Director, Transport Assessments Planning Services  
Department of Planning, Industry and Environment  
GPO Box 39 Sydney, NSW 2001

**Application: SSI 7485**

I write to you regarding the proposed modification to the M4-M5 Link, Mod 2 The Crescent overpass and changes to pedestrian infrastructure in North Annandale, Rozelle and Rozelle Bay foreshore areas.

Figure 4-2 Pedestrian and cyclist bridge infrastructure options

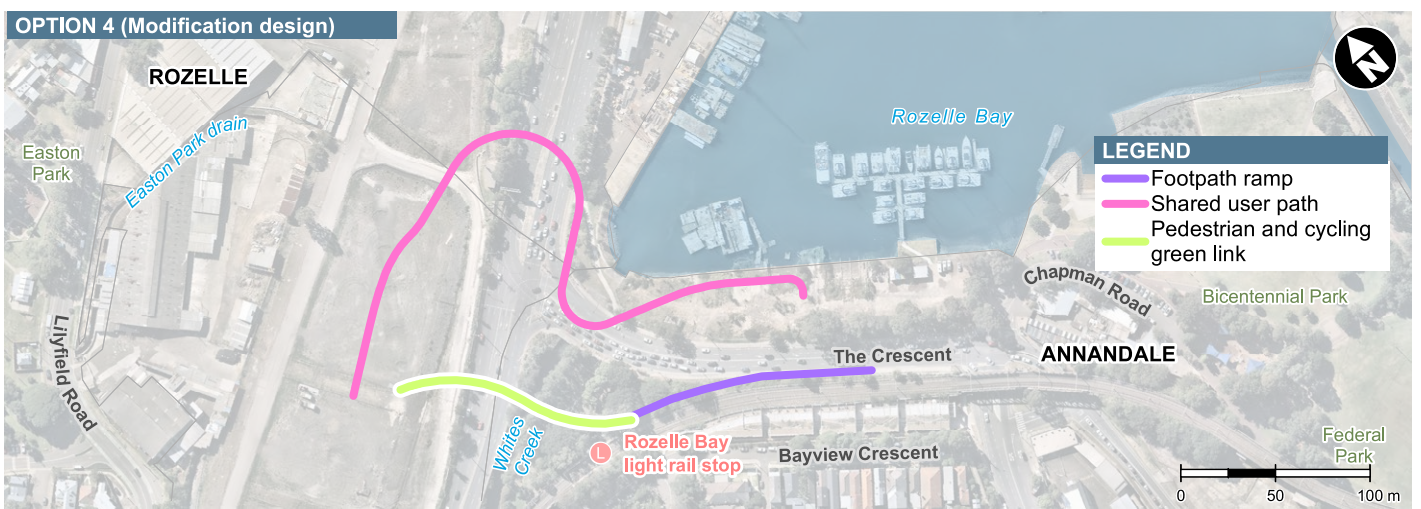
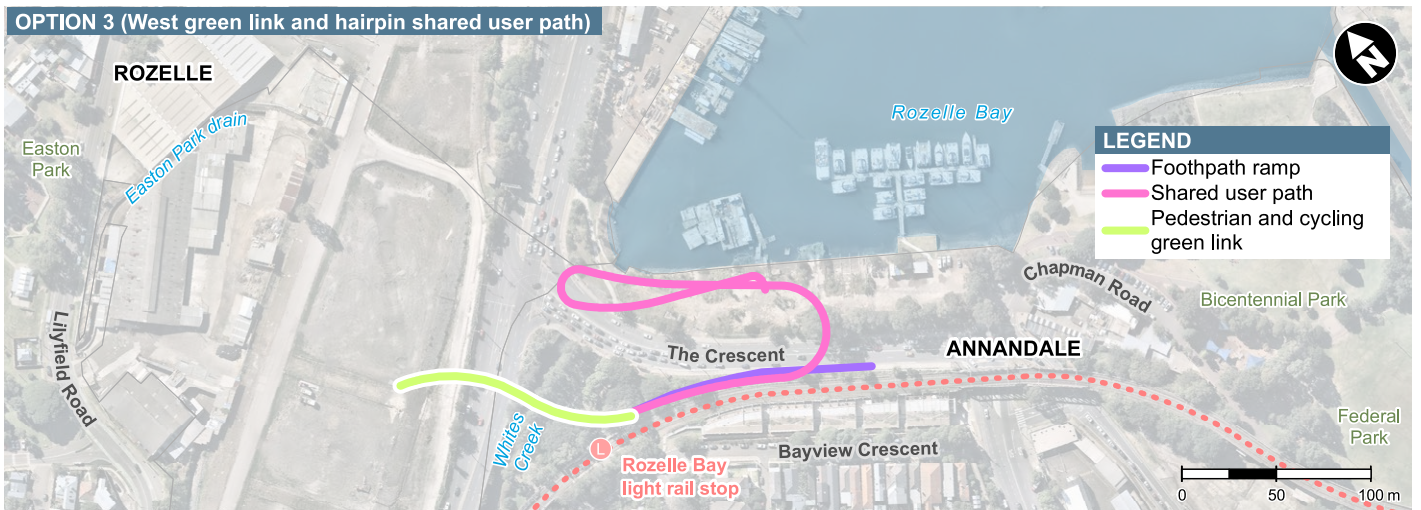
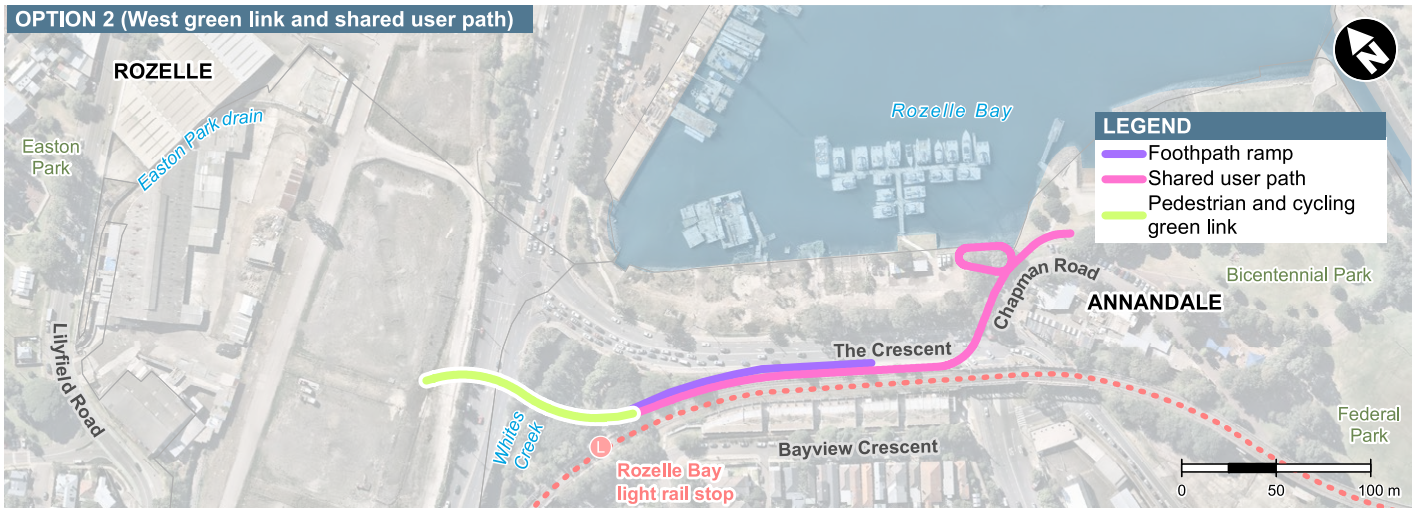
I am requesting the RMS to work collaboratively with the local community to explore alternative design options for the proposed new motor vehicle overpass design and altered pedestrian and cycle links and am seeking reinstatement of the previously approved EIS GreenLink.

My submission is requesting the RMS and Project team to reinstate the GreenLink connecting communities surrounding Rozelle Bay with the bay and with each other and to put people first in the design whereby pedestrian connections around our suburbs are made simple and not secondary to motor vehicle infrastructure.
